From: Bingham, Brad [bbingham@amafca.org]
Sent: Thursday, July 12, 2012 4:41 PM
To: Cherne, Curtis
Subject: RE: Balloon Fiesta Park Tribute Area Grading and Drainage Plan

From: Erin Canfield [mailto:ecanfield@bhinc.com]
Sent: Thursday, July 12, 2012 9:24 AM
To: Bingham, Brad
Cc: Gerald Parker
Subject: Balloon Fiesta Park Tribute Area Grading and Drainage Plan

From: Olson, Greg R.
Sent: Monday, August 20, 2012 12:54 PM
To: Gerald Parker (GParker@bhinc.com)
Cc: Olson, Greg R.; 'Bingham, Brad'; 'ECanfield@BHIInc.com'
Subject: B17/D001E - Balloon Park Tribute Area Grading Plan Approval
Attachments: B17_D001E Balloon Park Tribute Area-Grading Plan Approved.pdf; DPM-22_Grading Plan Checklist.pdf

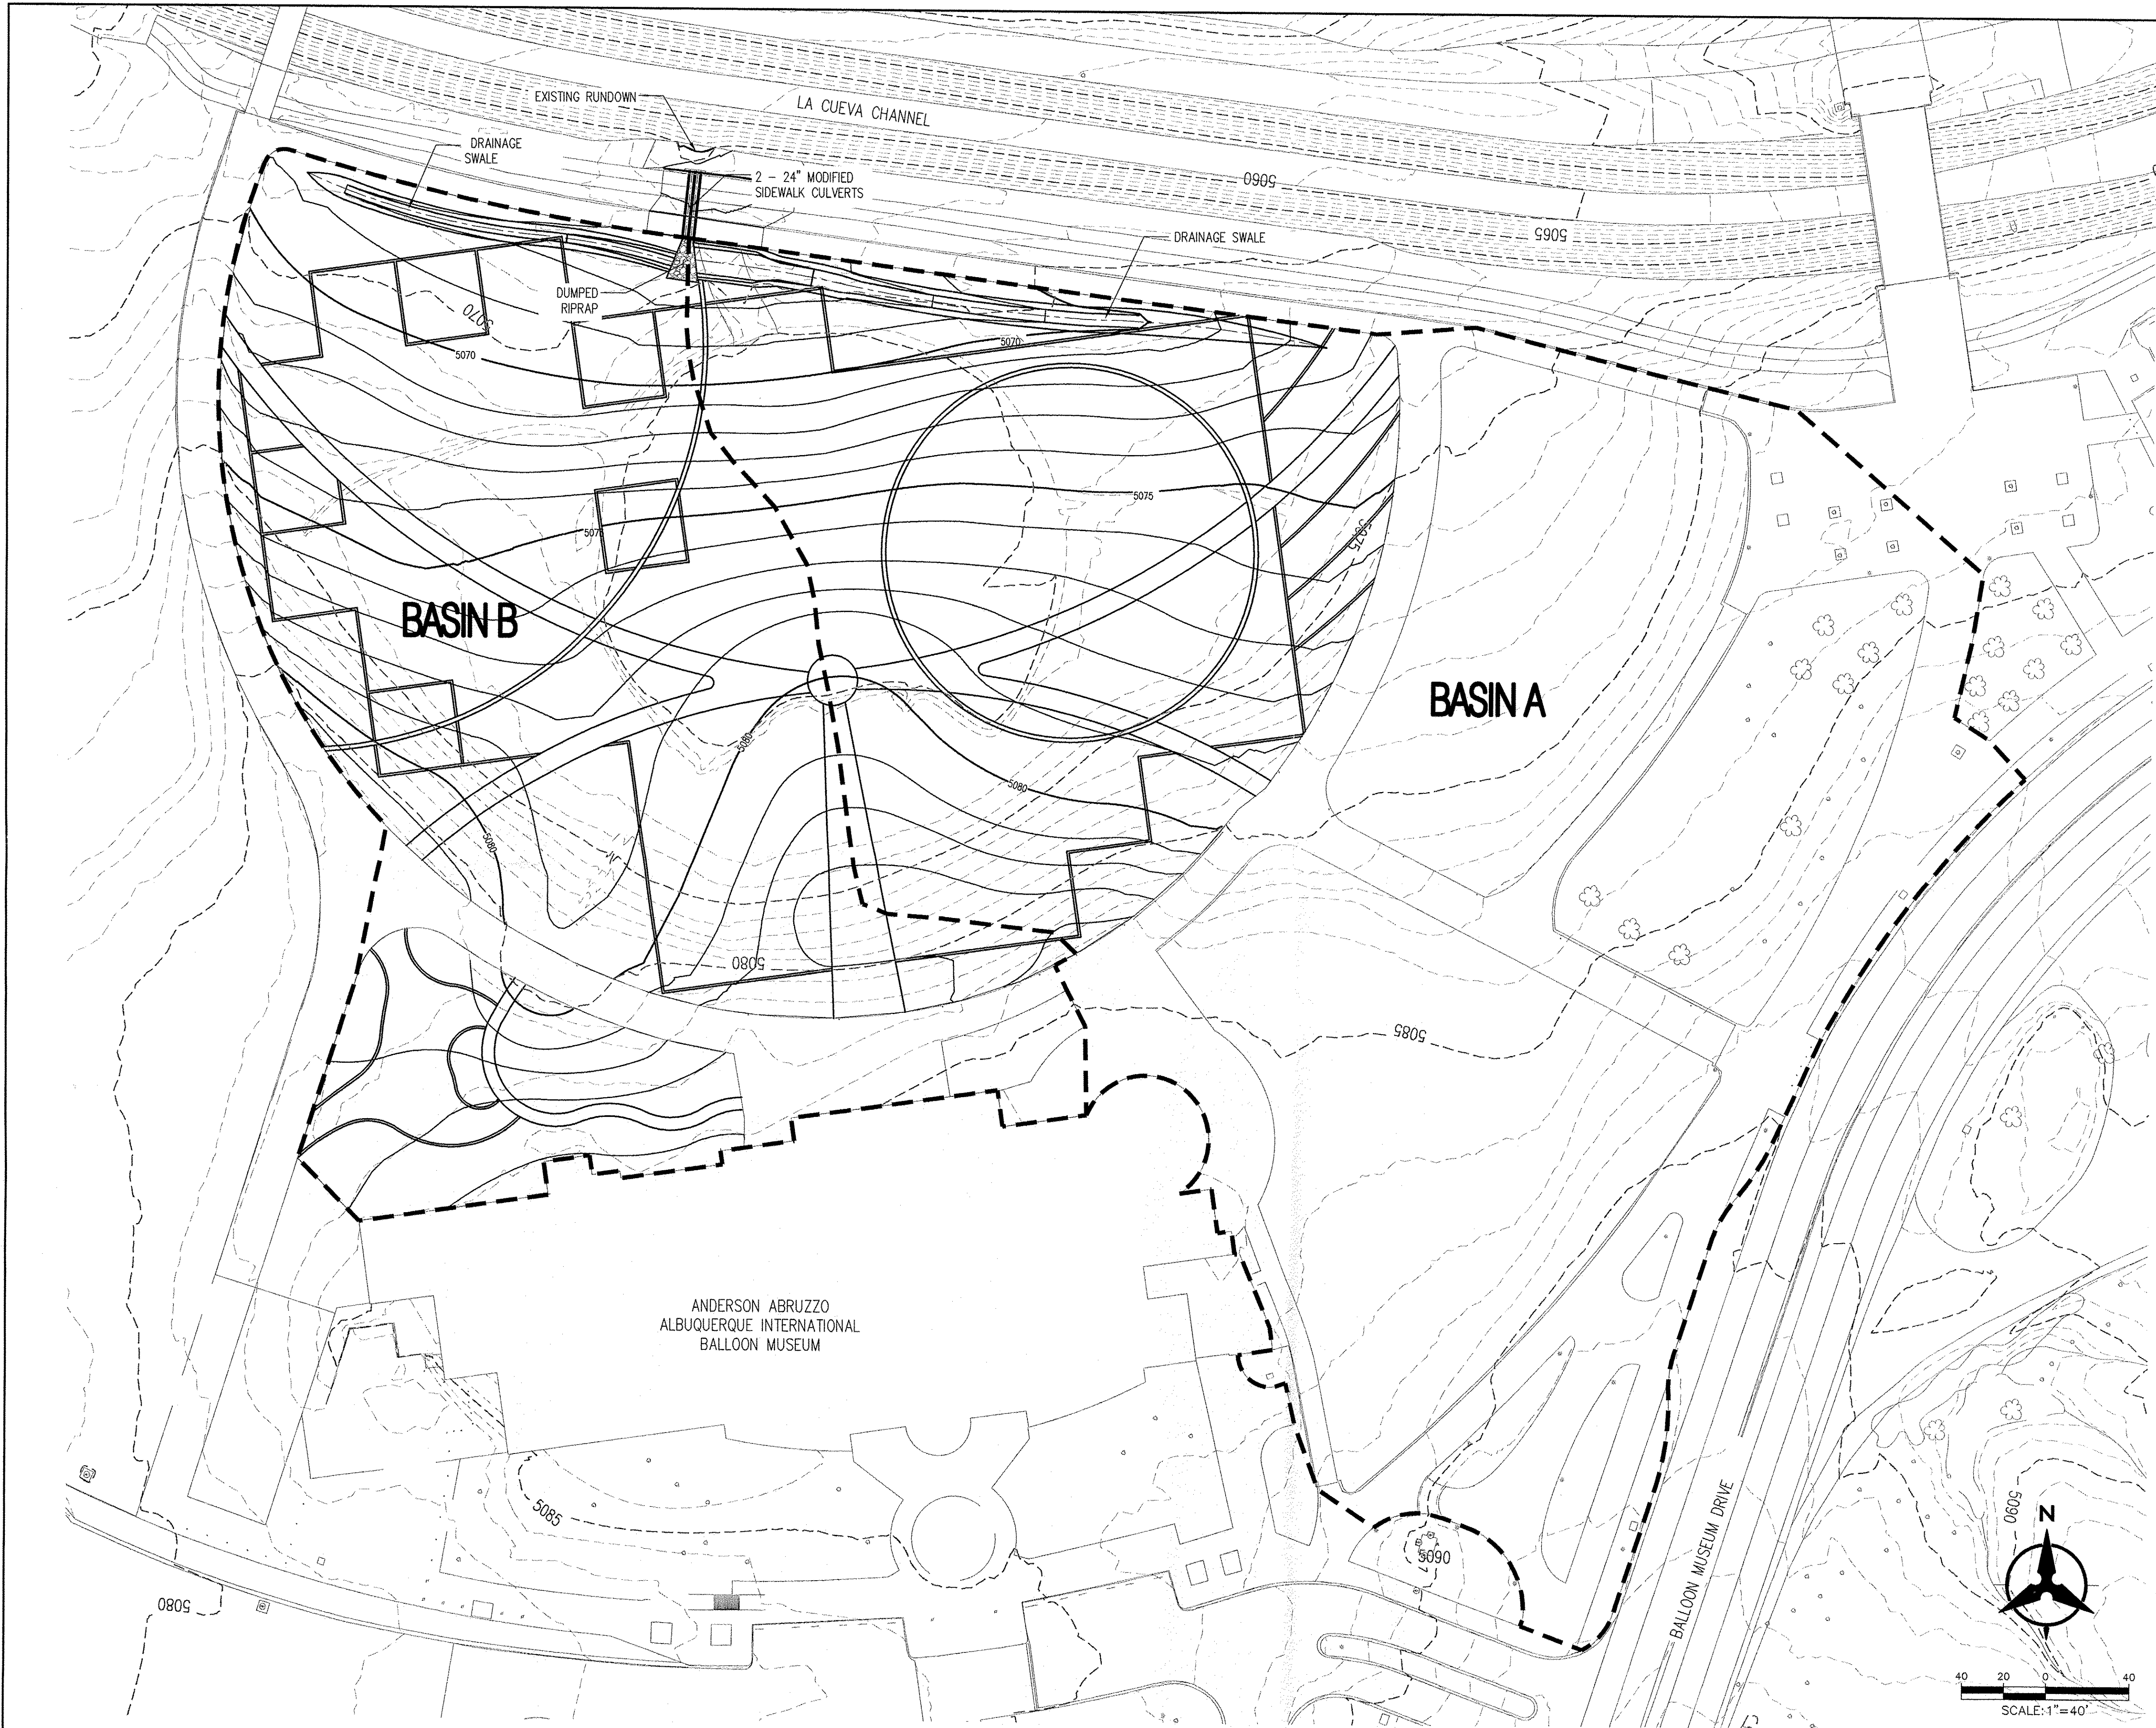
One observation, not included in my letter, is the fact that the concentrated flows (24cfs) from the new sidewalk culverts will discharge onto an unspecified layer of millings between the end of culverts and top of La Cueva Channel lining. This is in AMAFCA R/W.
